**University of Technology Sydney
Blackfriars Precinct Research Building Industry Hub
4-12 Buckland Street Chippendale NSW**

Response to Submissions

Section 4.55(2) Modification Application

**SSD 6746 Blackfriars Concept Development Proposal
UTS Blackfriars Precinct Research Building**

1. LOCATION PLAN

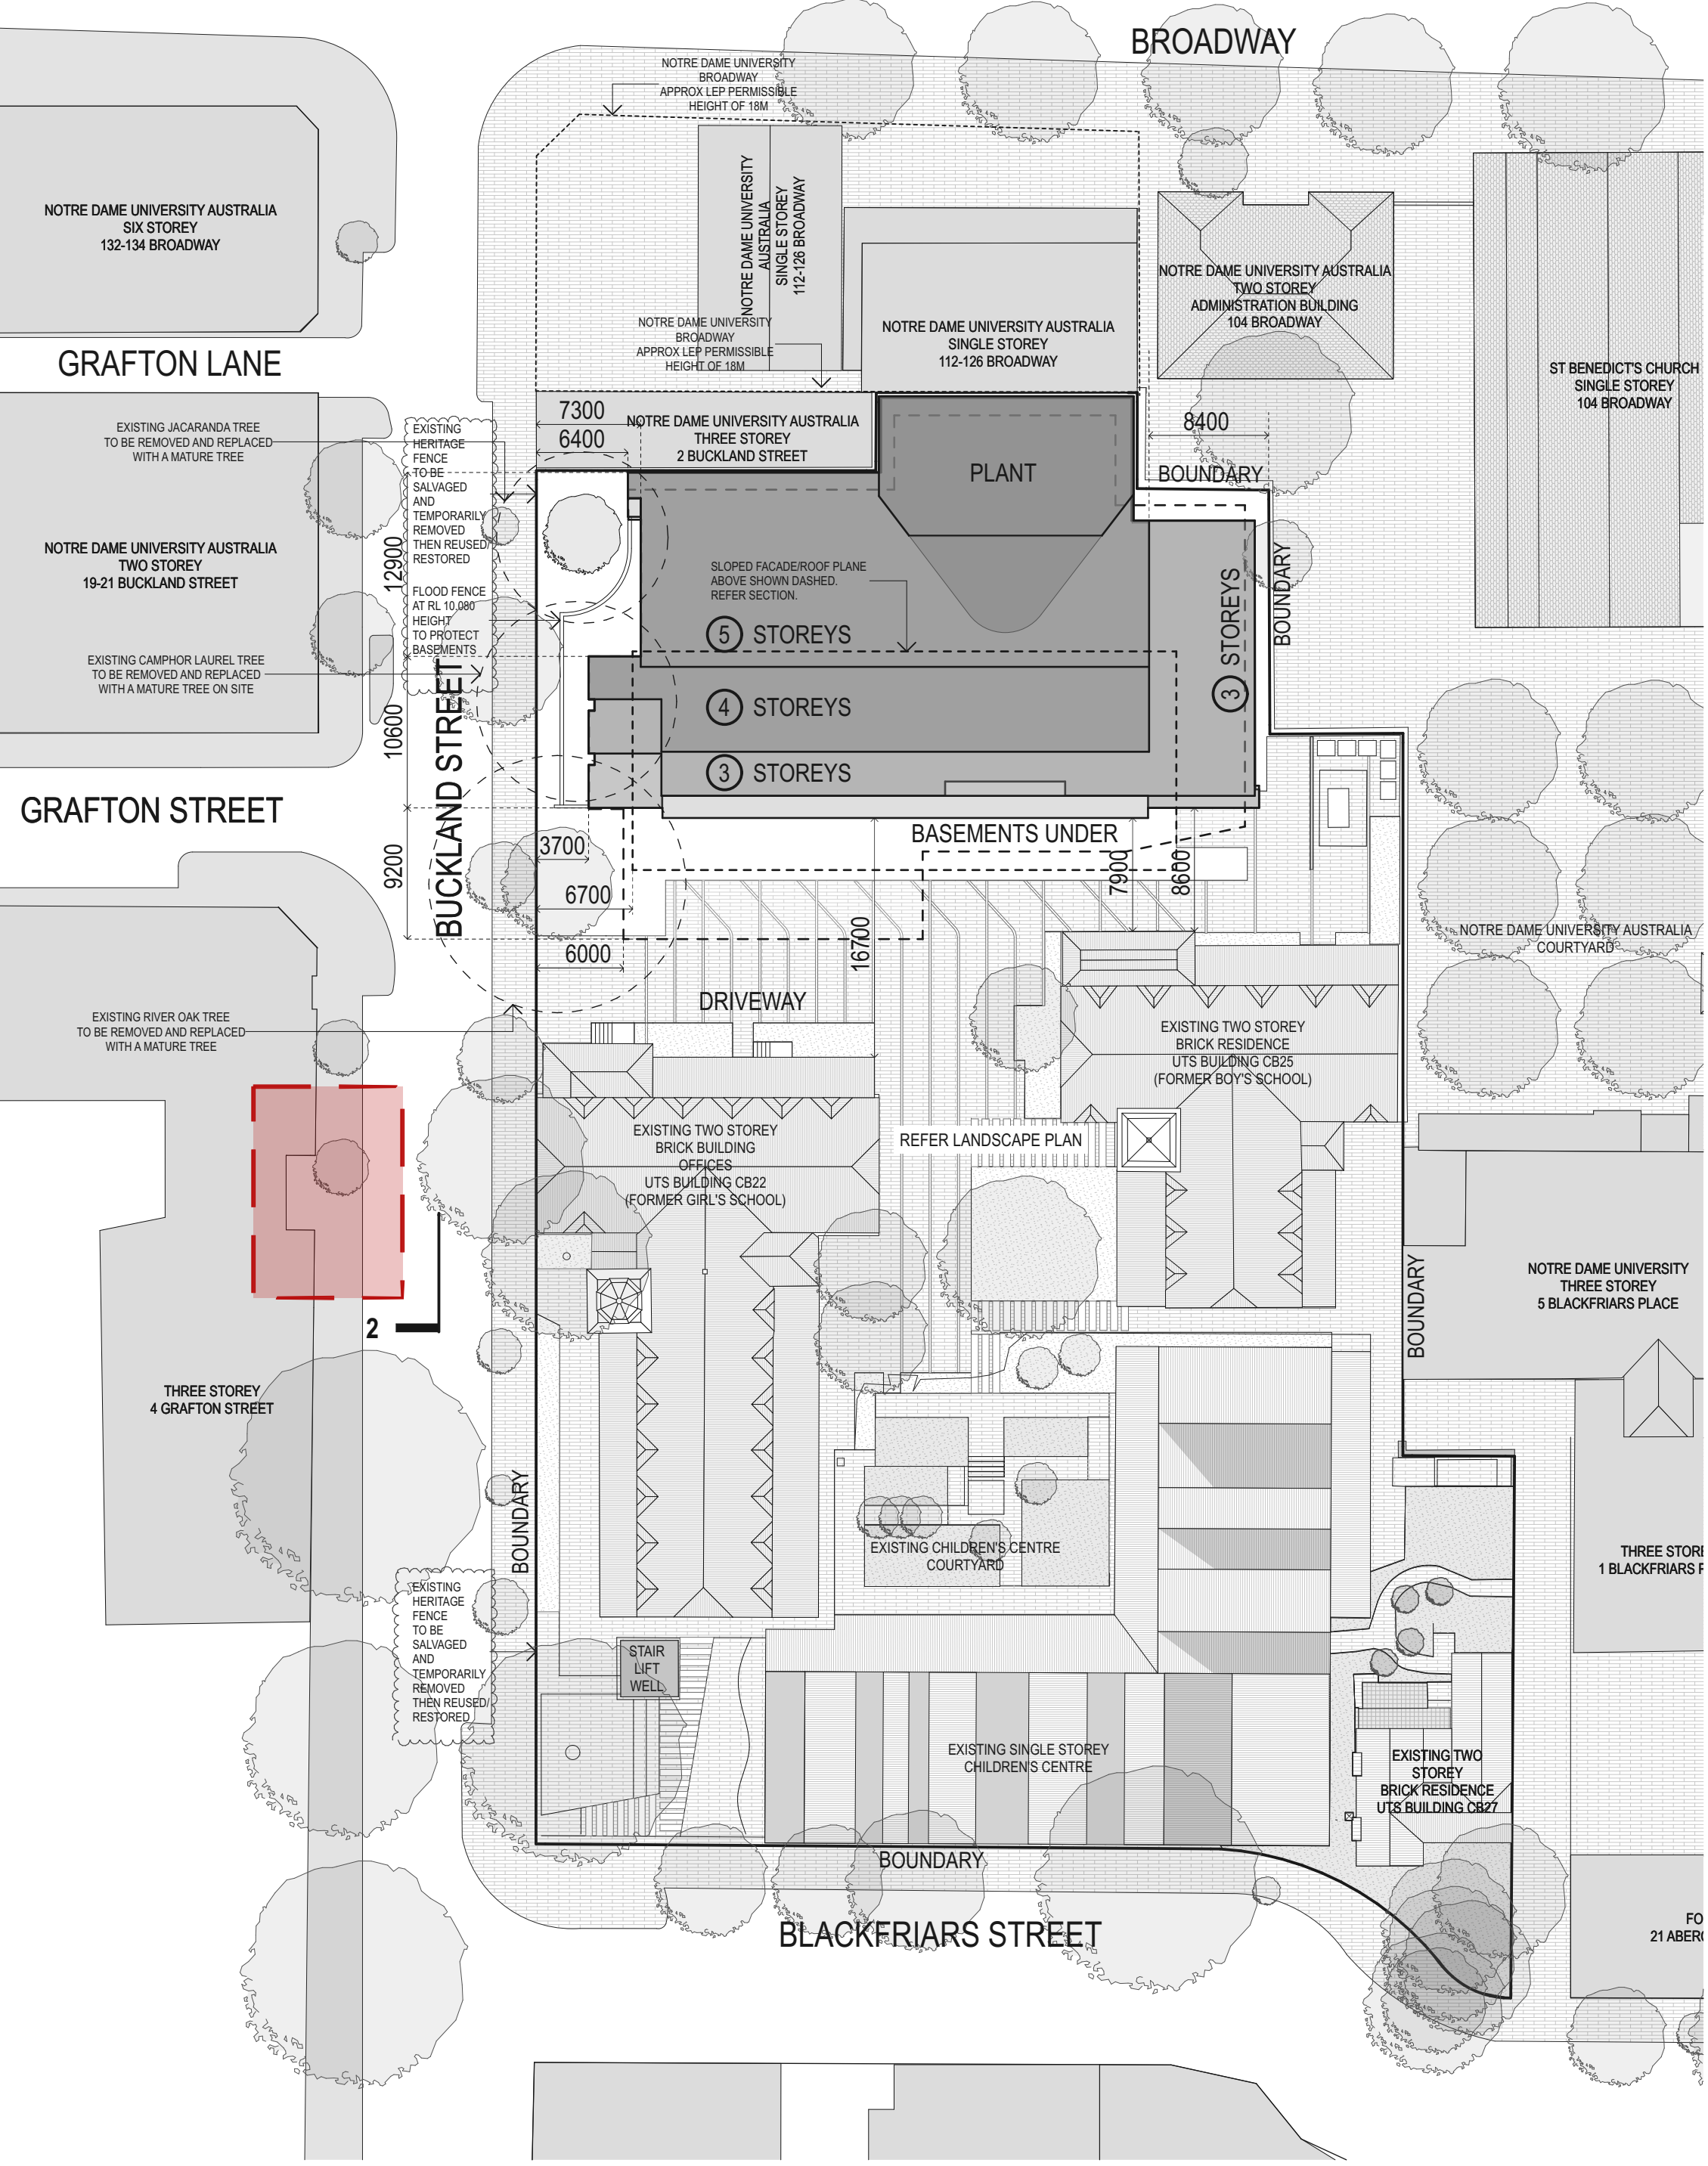
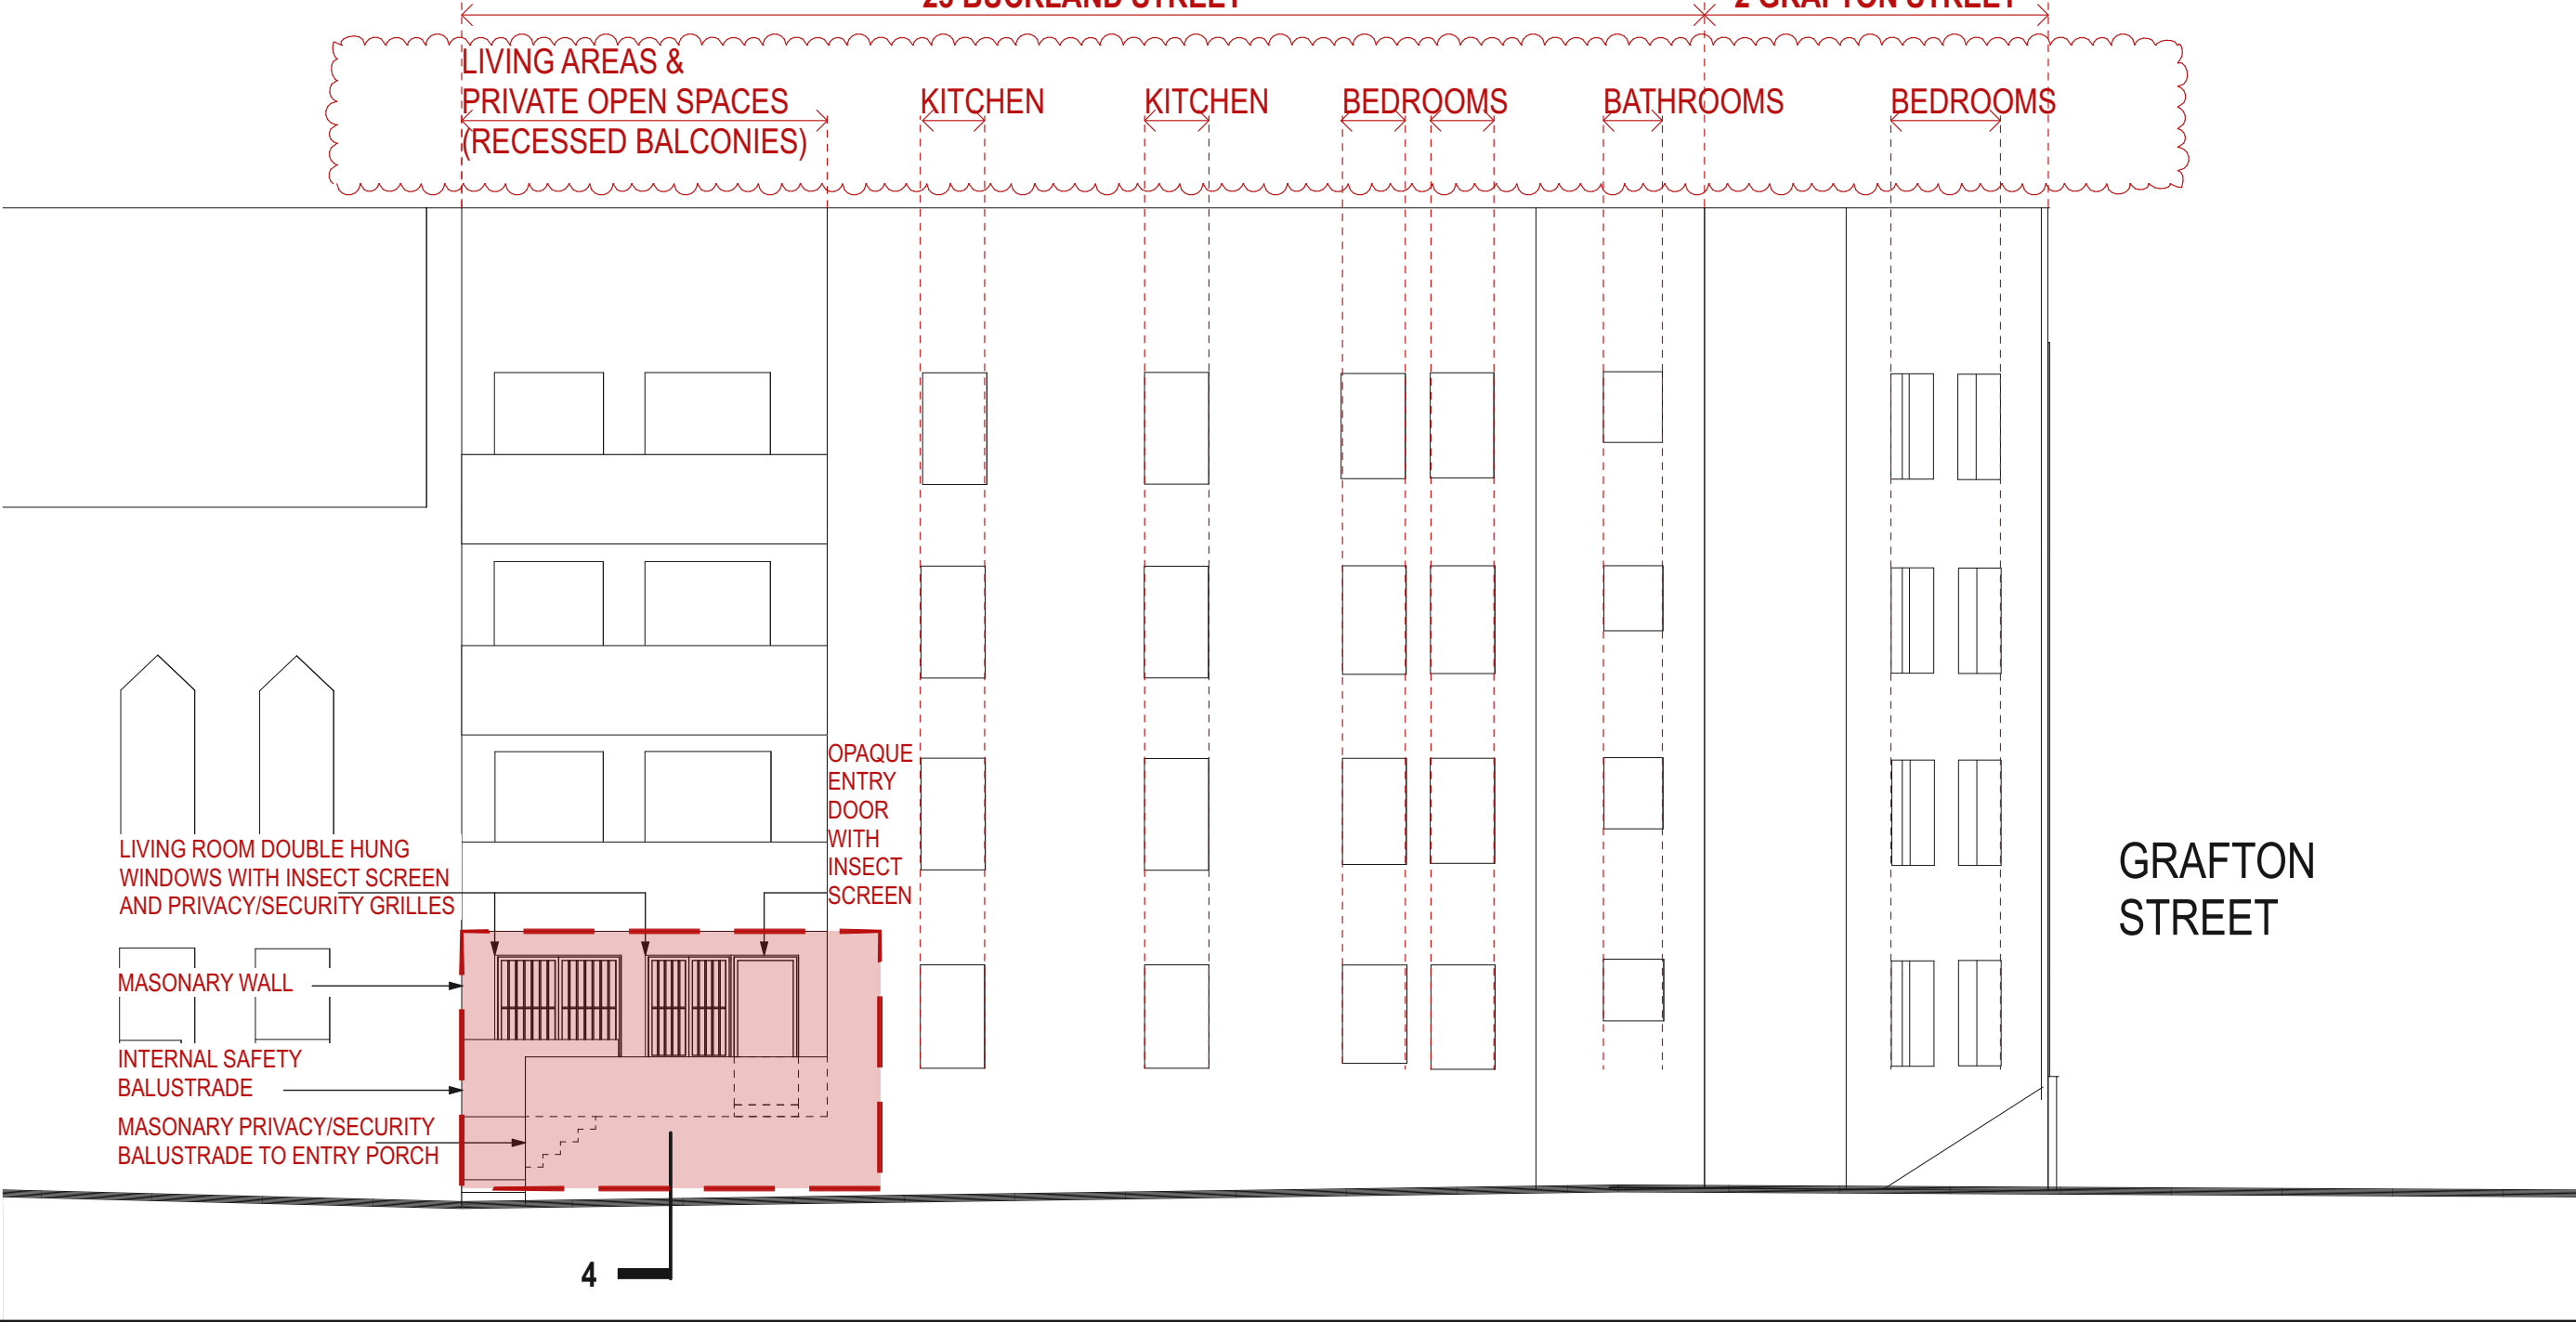
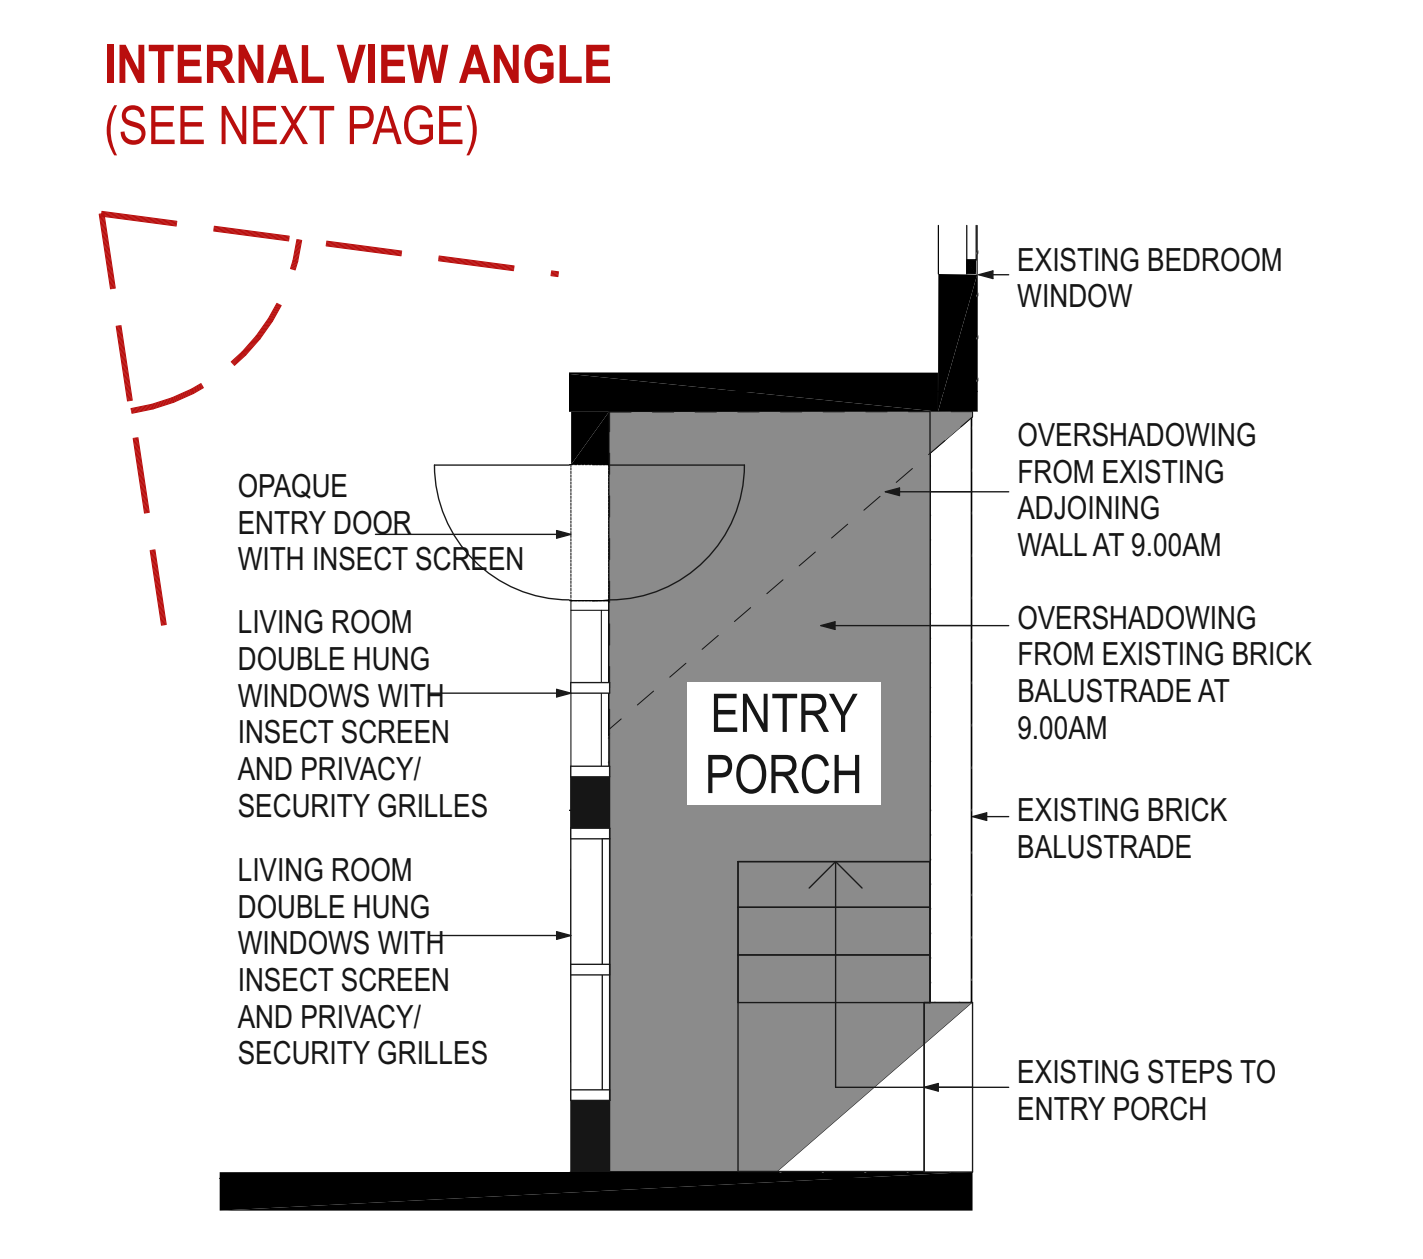
Council has raised a concern that the overshadowing information provided with the modification application is inadequate and it has questioned whether two hours solar access to 2 Grafton Street apartments is maintained. Council has also noted its position that solar access cannot be relied on to these apartments after 11.30 due to the orientation of Grafton Street – refer to Council's comments 1.d) at page 2 of its submission.

Figure 3 shows shadows from the proposed envelope as modified on the elevation of 2 Grafton St/23 Buckland Street in a three dimensional axonometric diagram. Taking into account which windows are to living areas and the location of private open space (as shown in Figure 2) Figure 3 clearly shows that the only dwelling whose private open spaces or living area room windows are affected by shadows from the proposed modified envelope after 9.30am is the ground floor unit of 23 Buckland Street (circled with a blue dotted line in the figure), unit 29.

The private open space of Unit 29 is configured as an accessway and public front entrance for the apartment and includes steps and an access path between the street and the apartment front door, as illustrated in Figure 5.

The proposed development does not cause significant additional overshadowing of this space after 9.00am because the space is already almost completely overshadowed by its high brick balustrade and by its indented northern wall. The only part that currently receives sun is an area of less than half a square metre at the bottom of the stair landing immediately adjacent to (and effectively an extension of) the footpath. It is considered that the residential amenity of this front space is of such low quality that the minor overshadowing of the bottom of the stair landing as a result of the proposed development between 9am and approximately 9.45am in midwinter will have no discernible impact on the amenity of this space or on the potential for this space to be used by residents.
